**Rampion 2 Offshore Wind Farm (Project Reference: EN010117)**  
**Principal Areas of Disagreement Statement (PADS) – Version 1**  
**West Sussex County Council**  
**November 2023**

This report has been prepared by West Sussex County Council (WSCC). WSCC is a host authority for the Rampion 2 Offshore Wind Farm DCO, which was accepted on 20 September 2023 by the Planning Inspectorate for Examination. This document identifies the initial principal areas of disagreement that have been identified following review of the DCO documentation.

Drawing file: EN010117 / EN010117-000162-2.6 Rampion 2 Tree Preservation Order and Hedgerow Plan.pdf

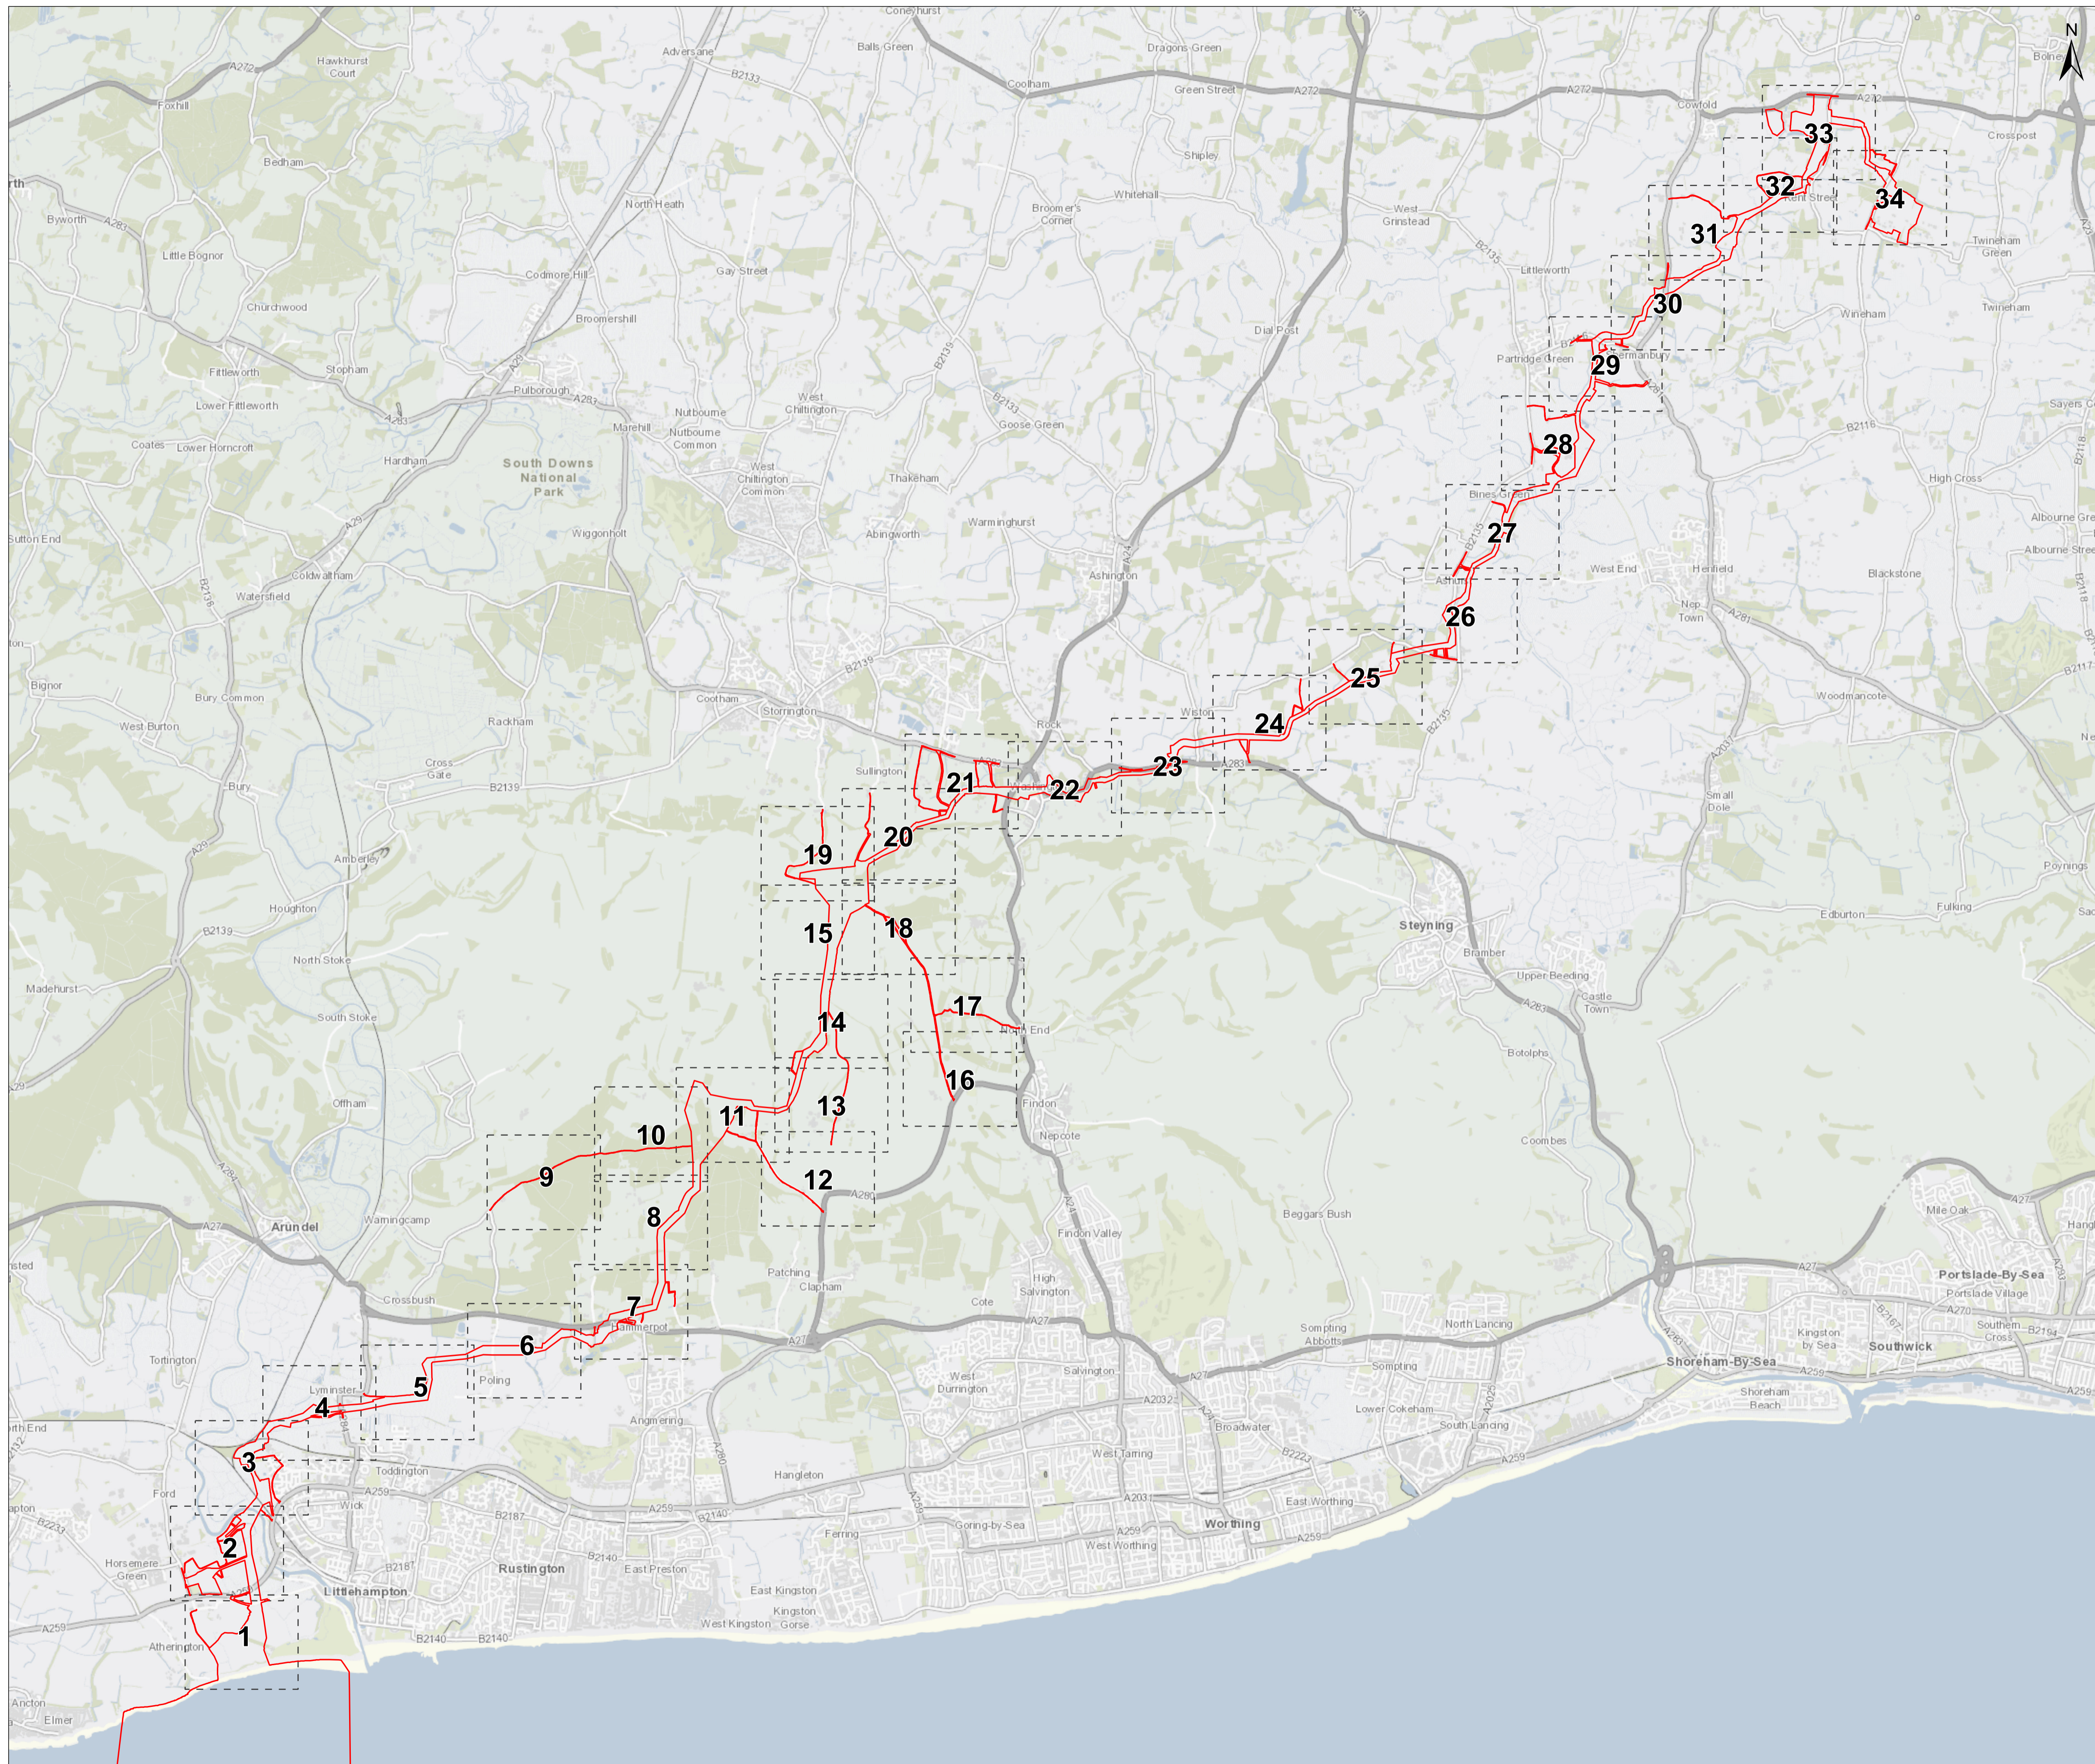
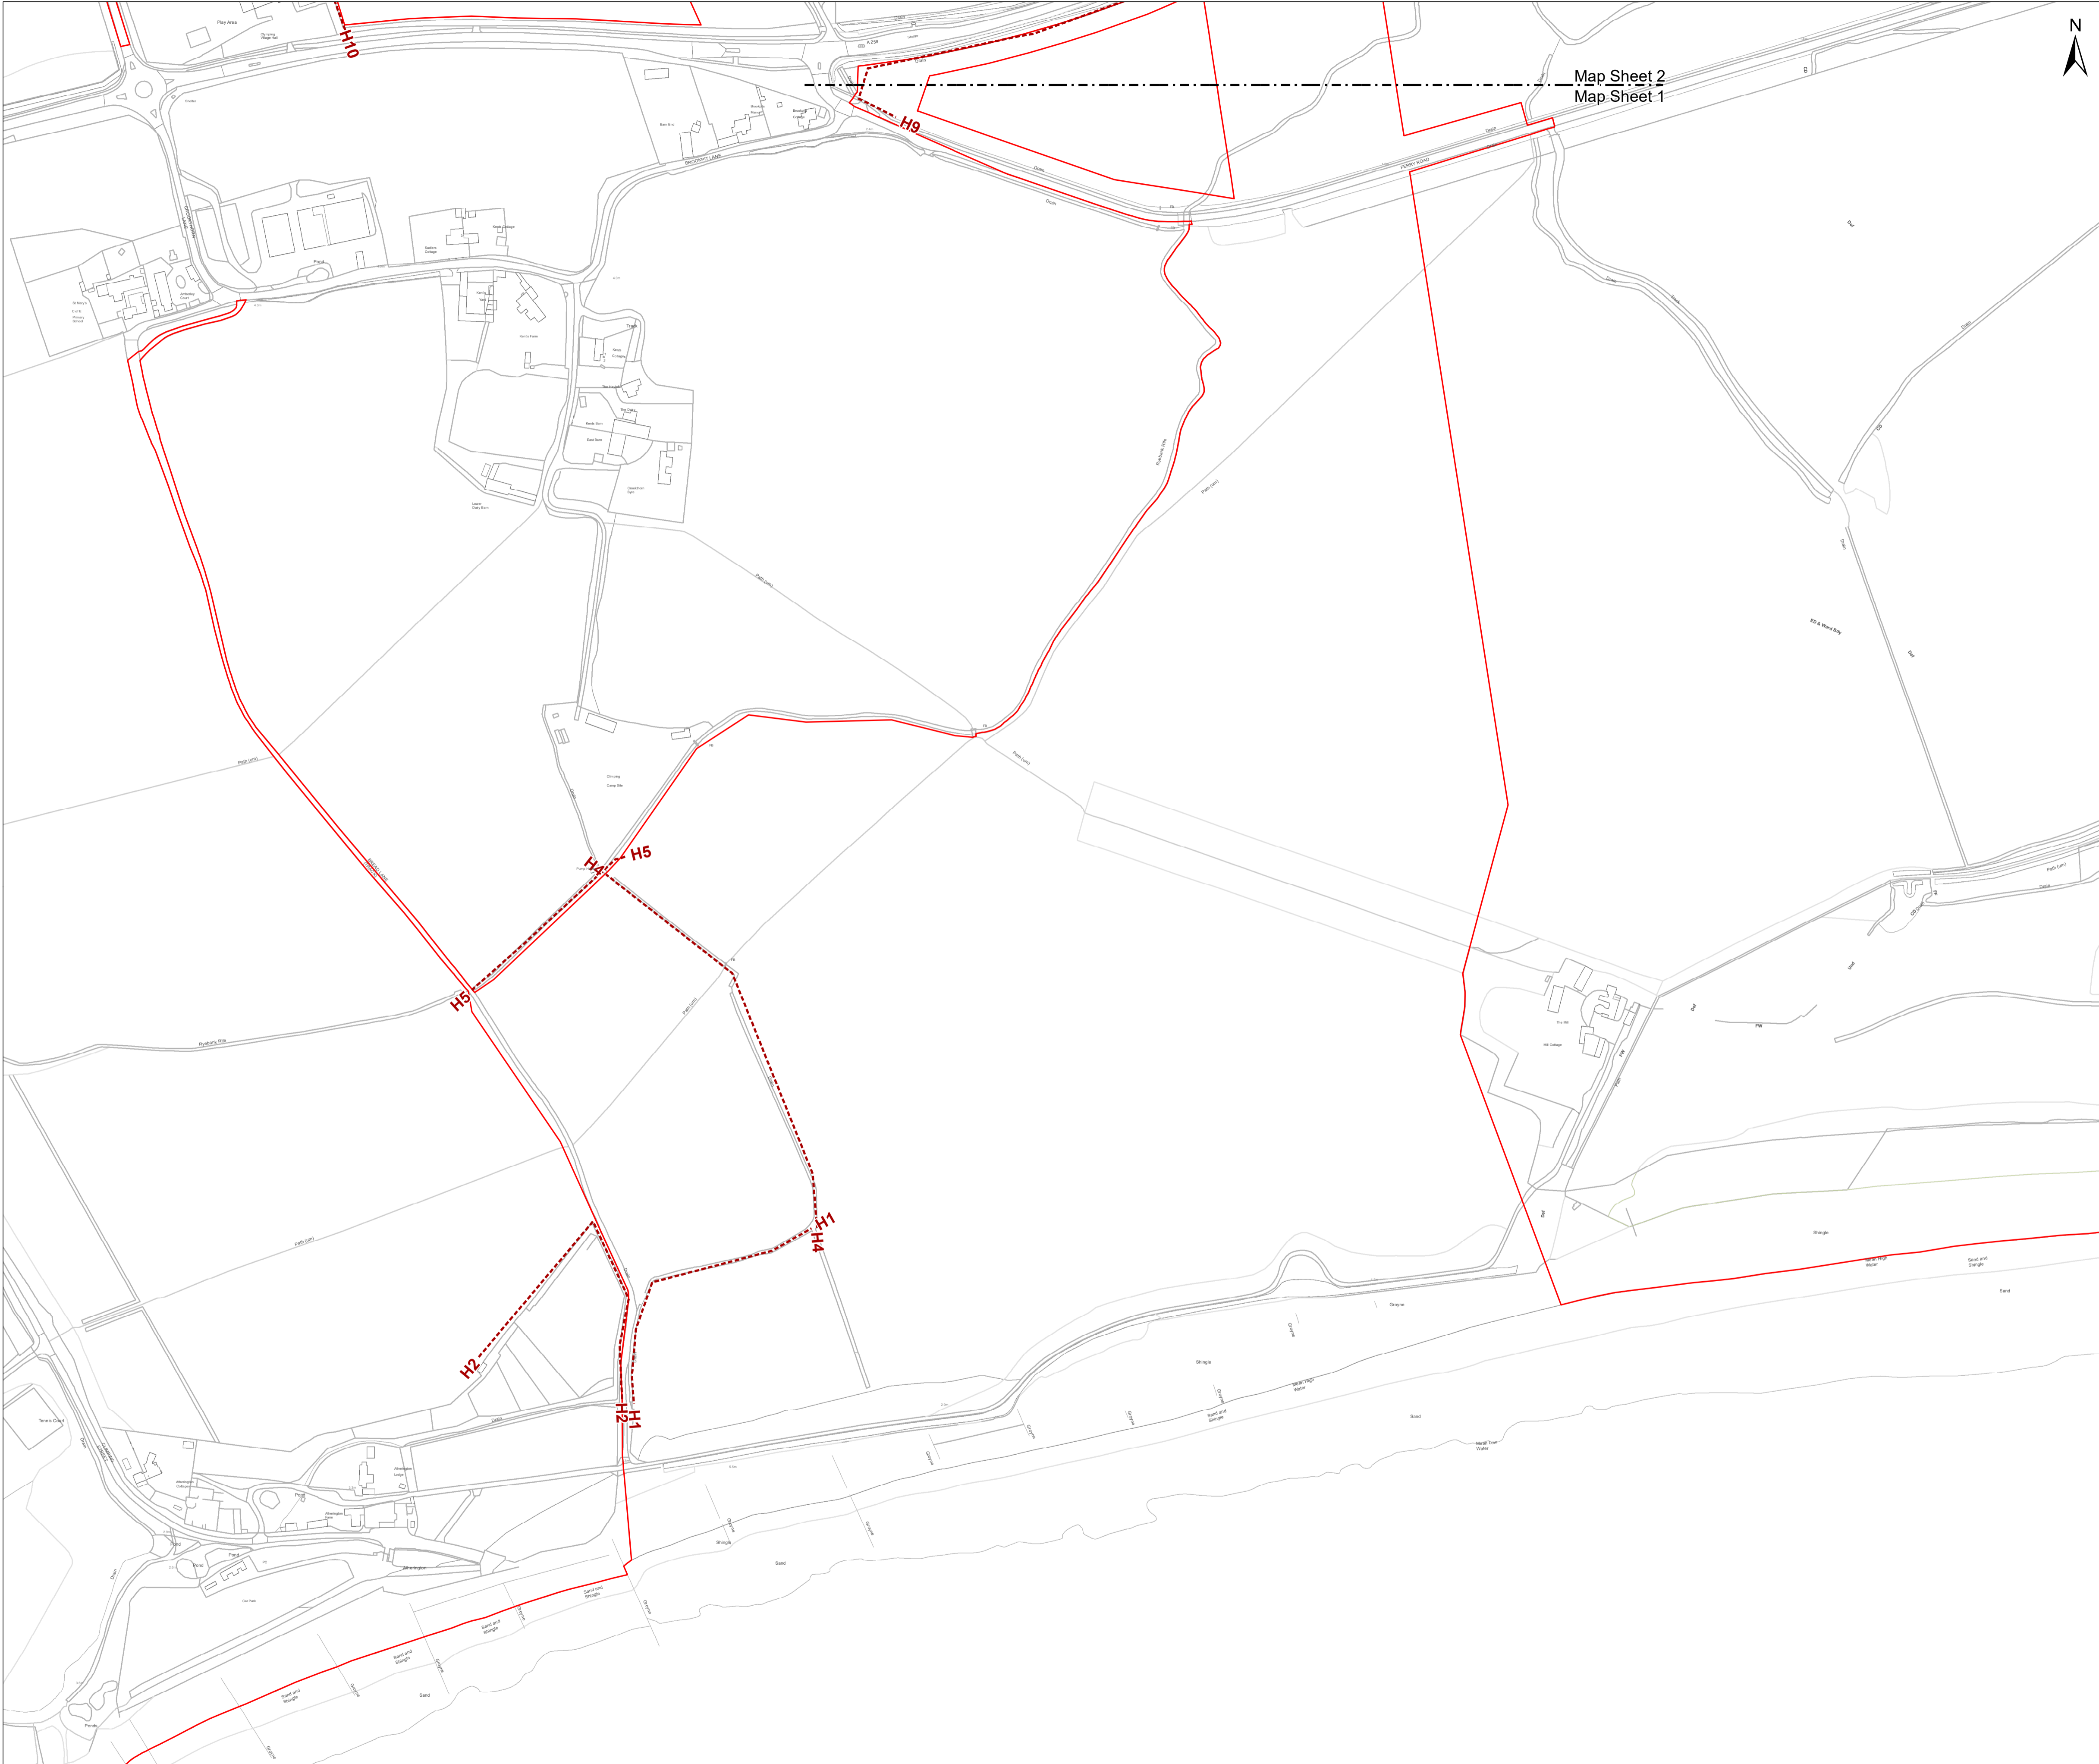
| 30.                          | Important hedgerows are not adequately identified across multiple documents and plans.   | Removal or damage caused to hedgerows including those determined as 'important'.  | The following must be consistent with hedgerow references and survey findings: Schedule 13; Tree Preservation Order and Hedgerow Plan; Hedgerow Survey Report; and Hedgerow Retention and Treeline Retention Plan.  | Uncertain |
